From: Iain Osenton
Sent: 19 October 2023 12:11
To: Suzanne Taylor
Cc: dcregistration; Planning
Subject: 23/00170/REM CDC Arboriculture

From desk based assessment.
Comment – No objections.

TITLE
MIDDLETON STONEY ROAD,
SECONDARY ROAD JUNCTION.
GENERAL ARRANGEMENT
SHEET 2

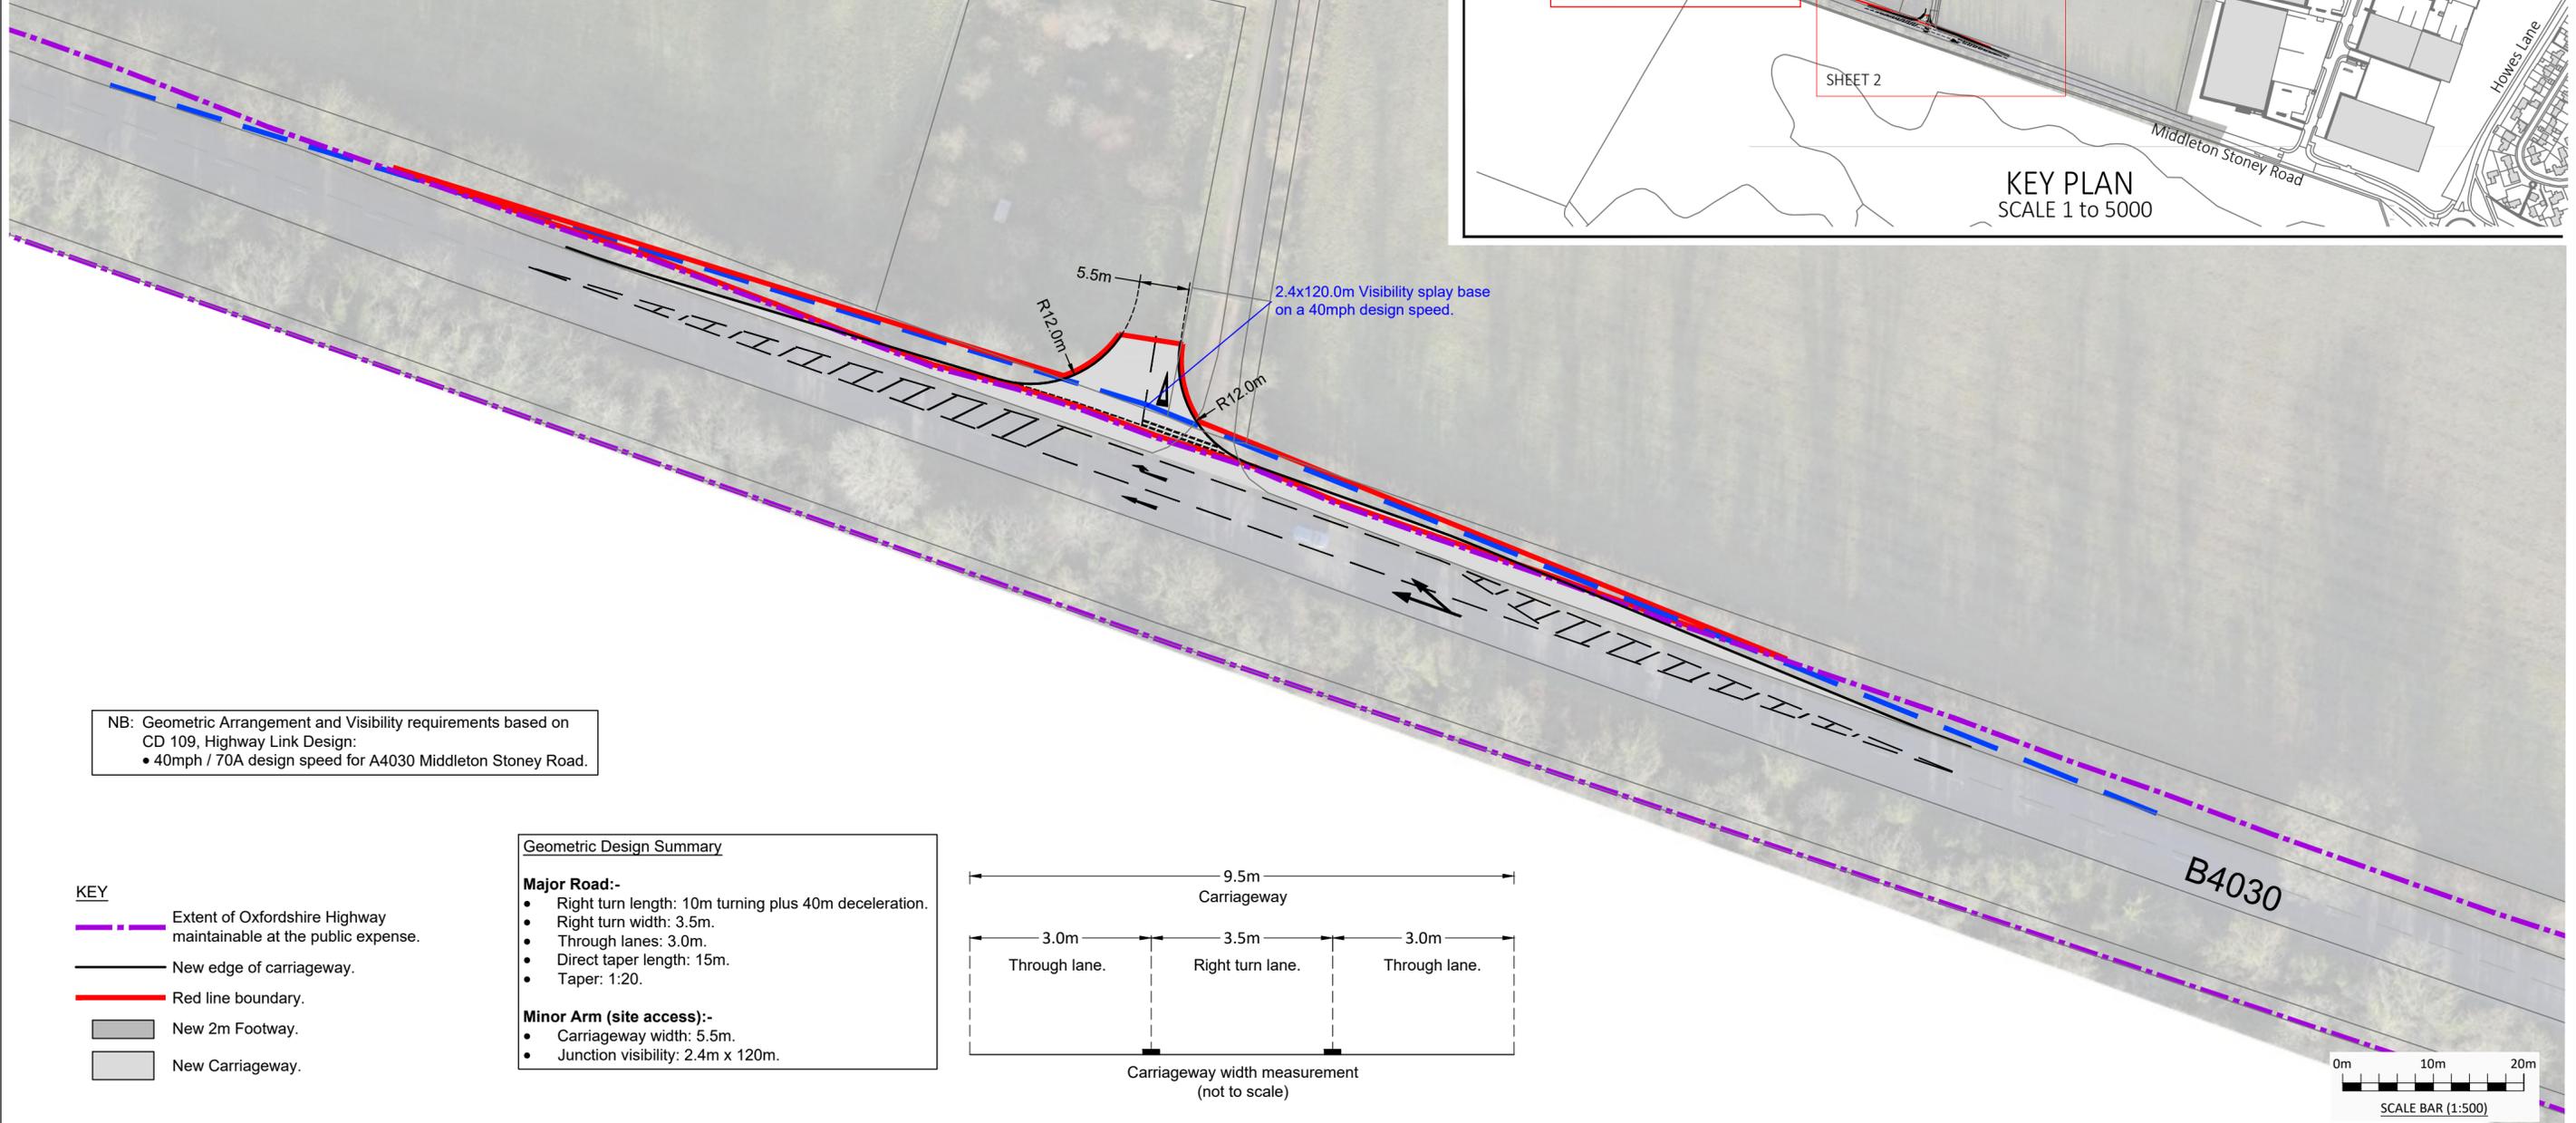
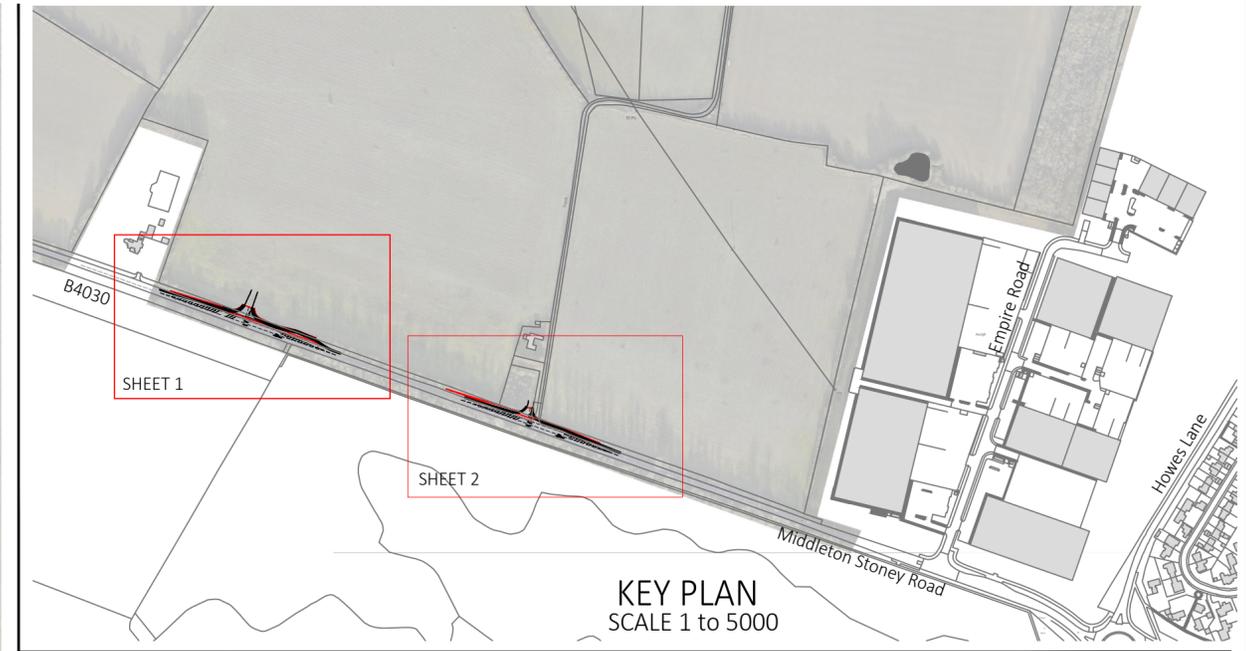
The proposal requires removal of x2 30m sections of BS5837:2012 category C hedgerow. Category C under BS5837 is not considered a major constraint to development, I'd request though this is considered alongside any further removals in order to condition appropriate replacement planning or mitigation for the removals by way of hedge improvement elsewhere within the site.
